CONSULTEE RESPONSE (Council's Arboriculturist)

Reference: **AL/49/22/PL**

Proposal: Demolition of all existing buildings and structures and redevelopment of the existing car salvage and recycling facility to provide 80 No dwellings and a co-working hub, with vehicular access from Fontwell Avenue, provision of public open space, landscaping, and other associated works. This application is a Departure from the Development Plan is in CIL Zone 3 and is CIL Liable as new dwellings

Location: Sussex Recovery Company, Fontwell Avenue, Eastergate, PO20 3RU

Tree Retention/Loss & Protection Plan (Demolition)

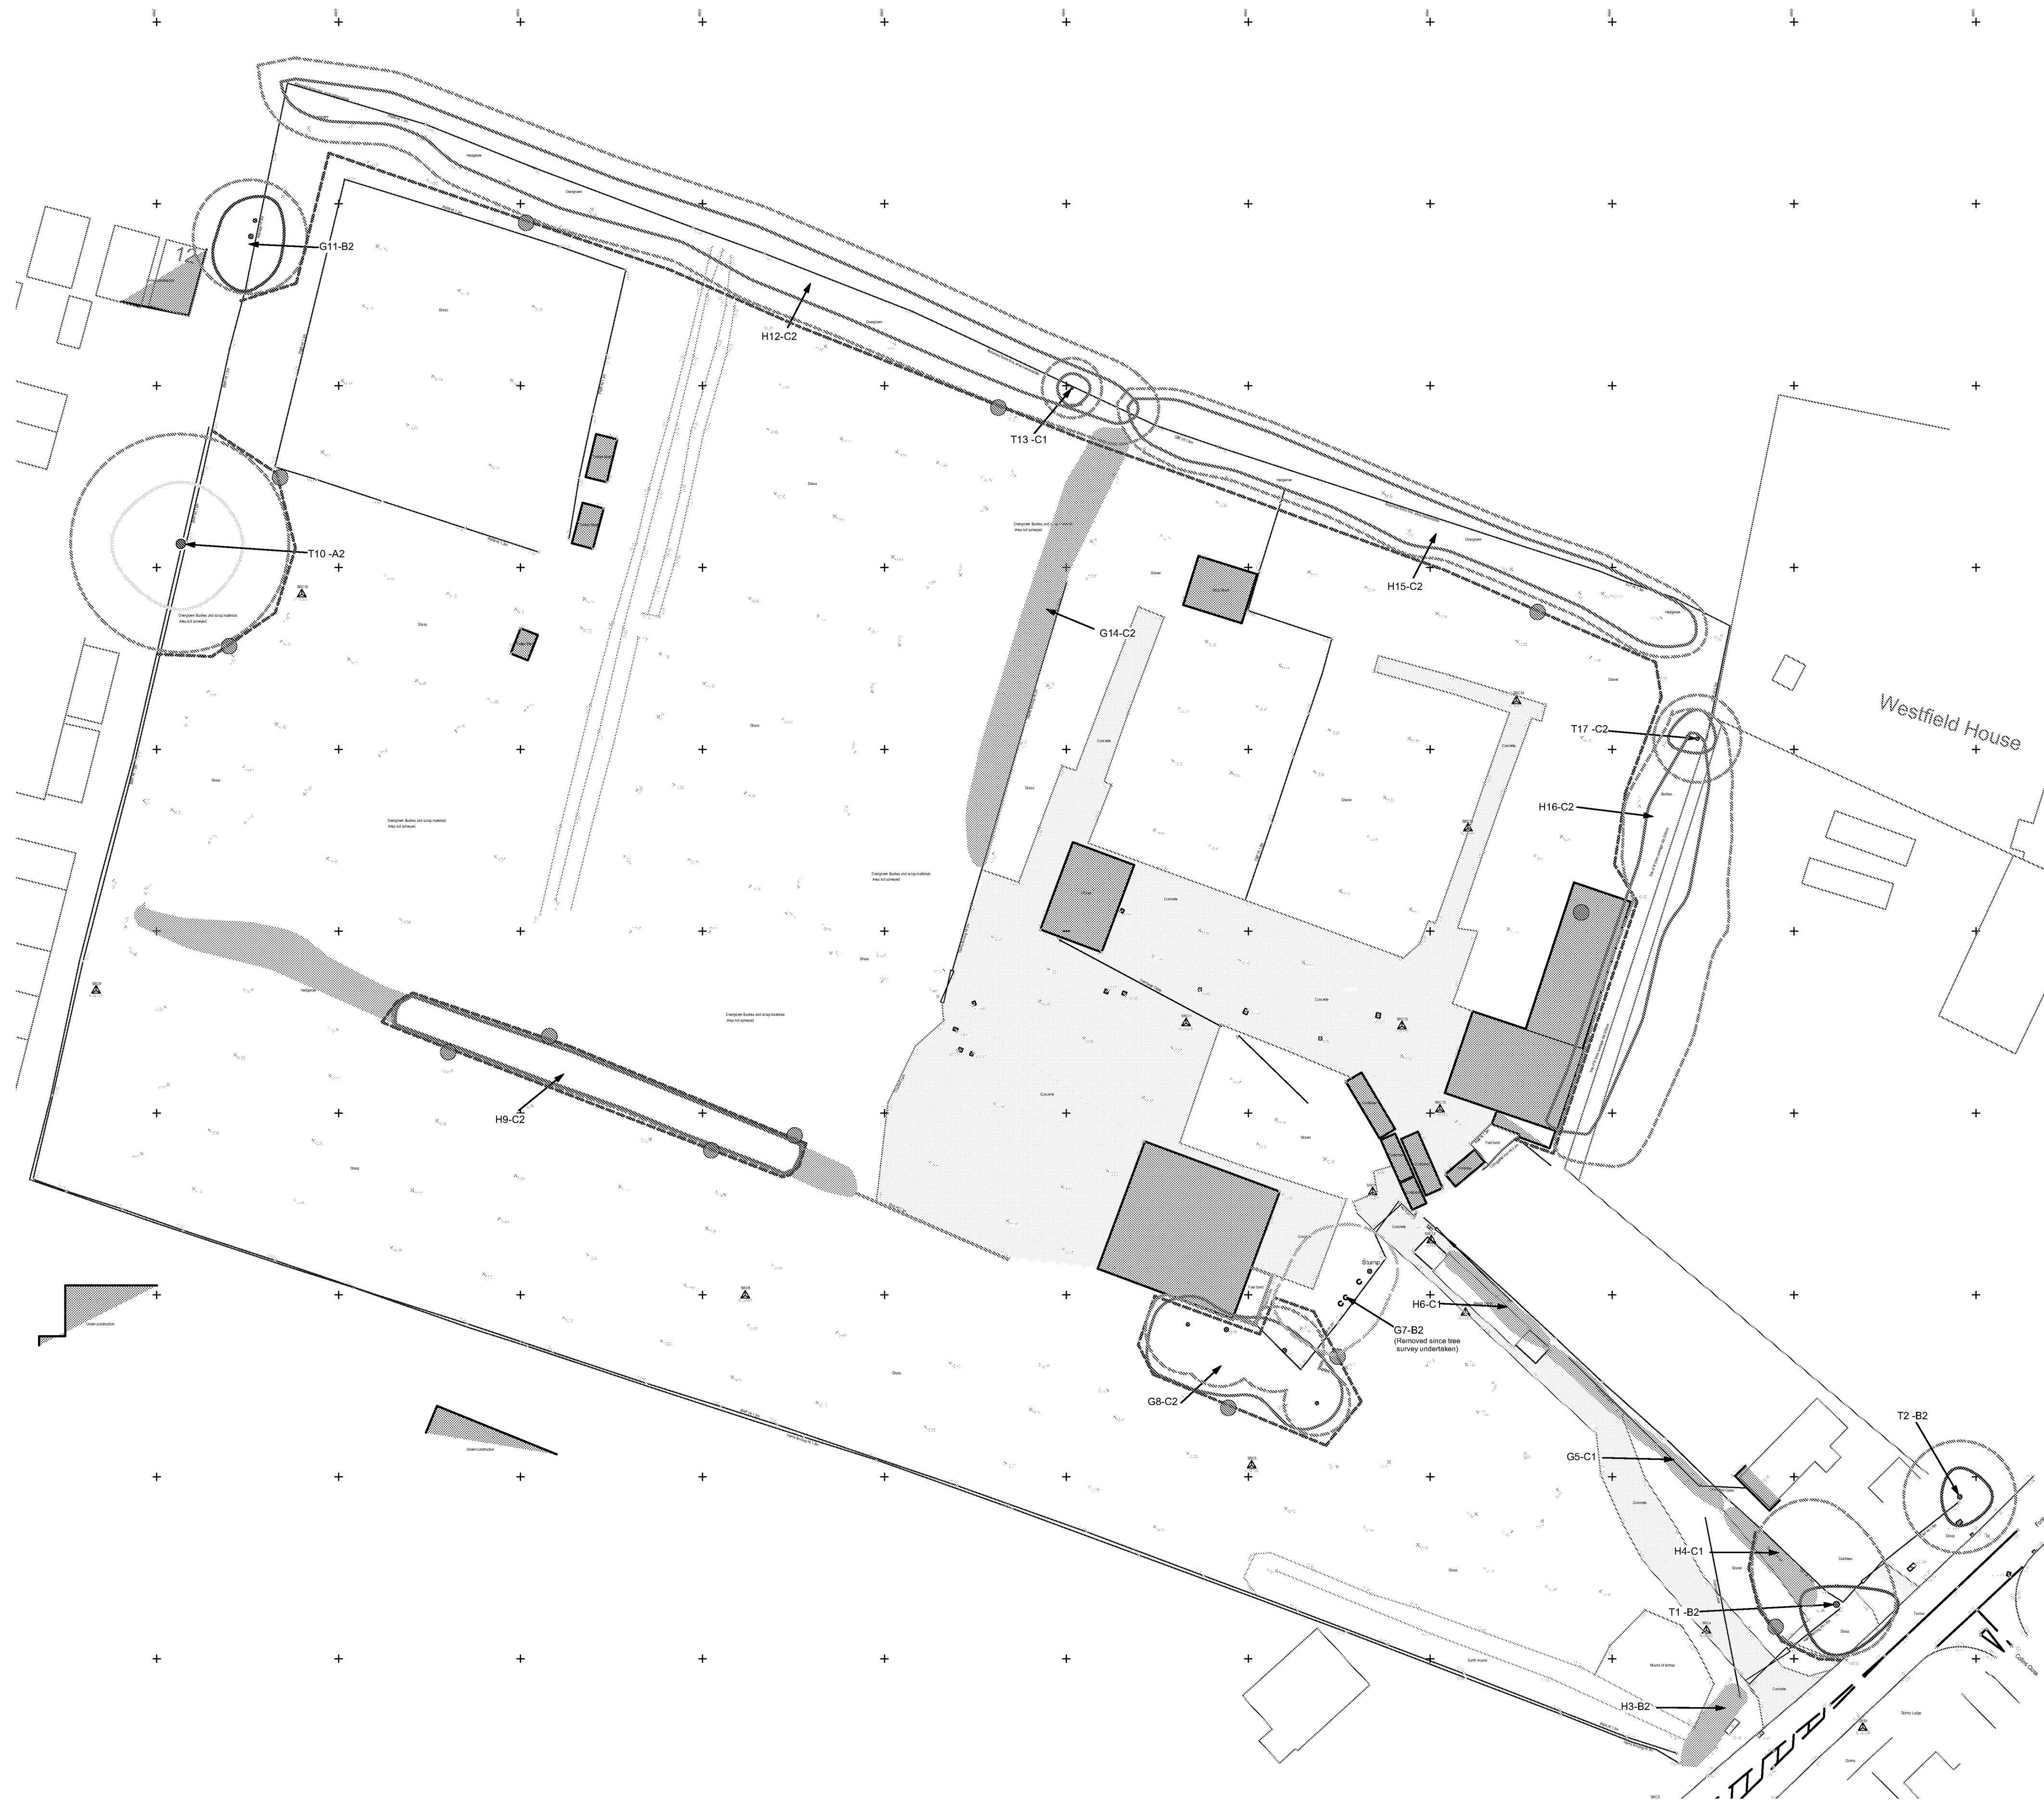
Before the site is occupied or any machinery is introduced to the site or demolition work or construction work or alterations to existing ground levels takes place; a detailed and bespoke Arboricultural Method Statement (AMS) would have to be submitted (to include mitigation of impact on roots of retained hedgerow and trees from installation of garden fencing and grubbing out of vegetation H4 within RPA of T1).

Tree Protection Plan (Construction)

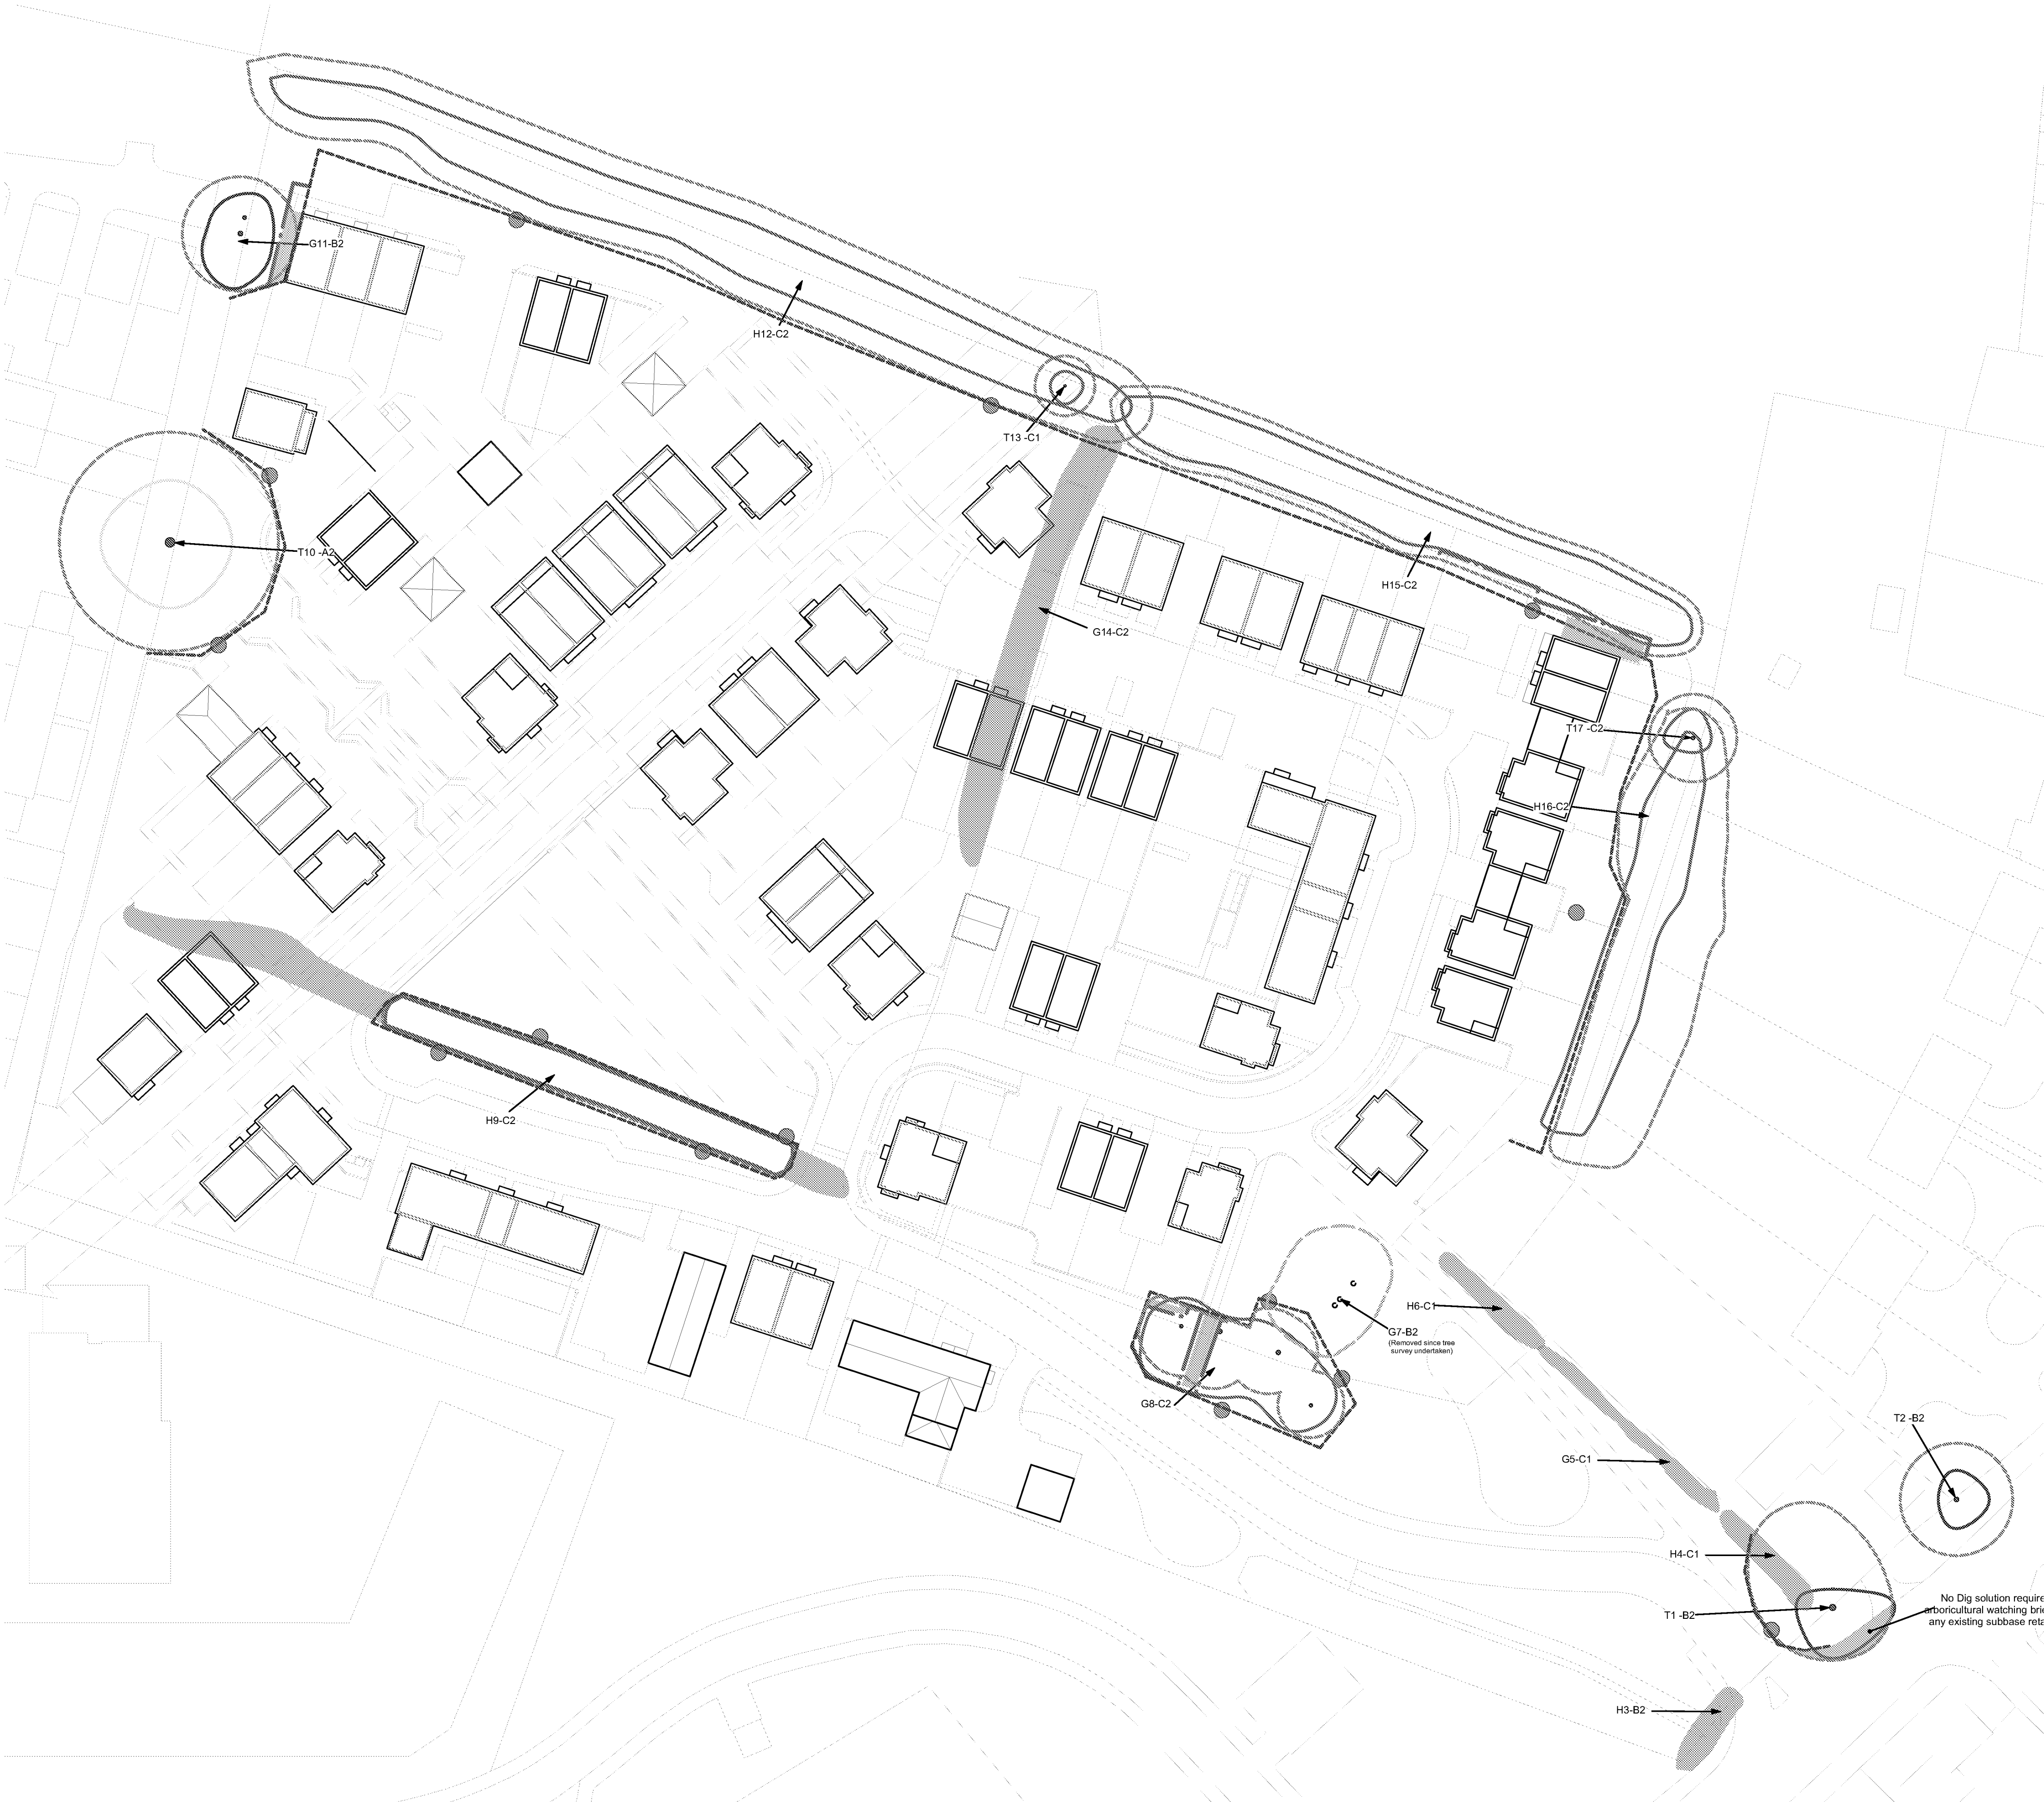
T1 - Can/will endure demolition of existing hard standing (if adequately supervised and supported by approved Arboricultural Method Statement), but a new access road is likely to require deeper and kerb-edged construction within the root protection area (RPA).

Opportunity exists to shift access south to avoid potentially damaging incursion.

The application of a morphed RPA seems to have been undertaken to fit the proposed access road rather than influence design of same. I suggest it is highly likely that roots extend farther than shown into the area of compacted ground (currently used for parking) and beneath the concrete access road. Root growth will have been resisted mostly by the presence of deeper construction (A29 carriageway) and so the tree will have compensated for that within the site.

T10 – RPA for this high value tree requires additional buffer zone (see guidance in Supplementary Planning Documents) to ensure no risk of construction overspill into exclusion zone. Furthermore this tree should not be confined but made a focal point from within the development. It must be afforded sufficient room to allow future growth and transition to veteran status, to prevent it being diminished in the landscape by application of risk mitigation pruning.

T1 and T10 are of such importance (high amenity/landscape value, potential heritage tree) and sensitivity (mature, growing in increasingly hostile surroundings) that they should represent major constraints to development. As such, it is reasonable for any proposal to avoid incursion into their nominal root protection area (RPA), especially where modifying a layout still permits the fundamental aim and size of the scheme to be delivered.

Layout should be revised to ensure successful long-term retention of T1 and T10.
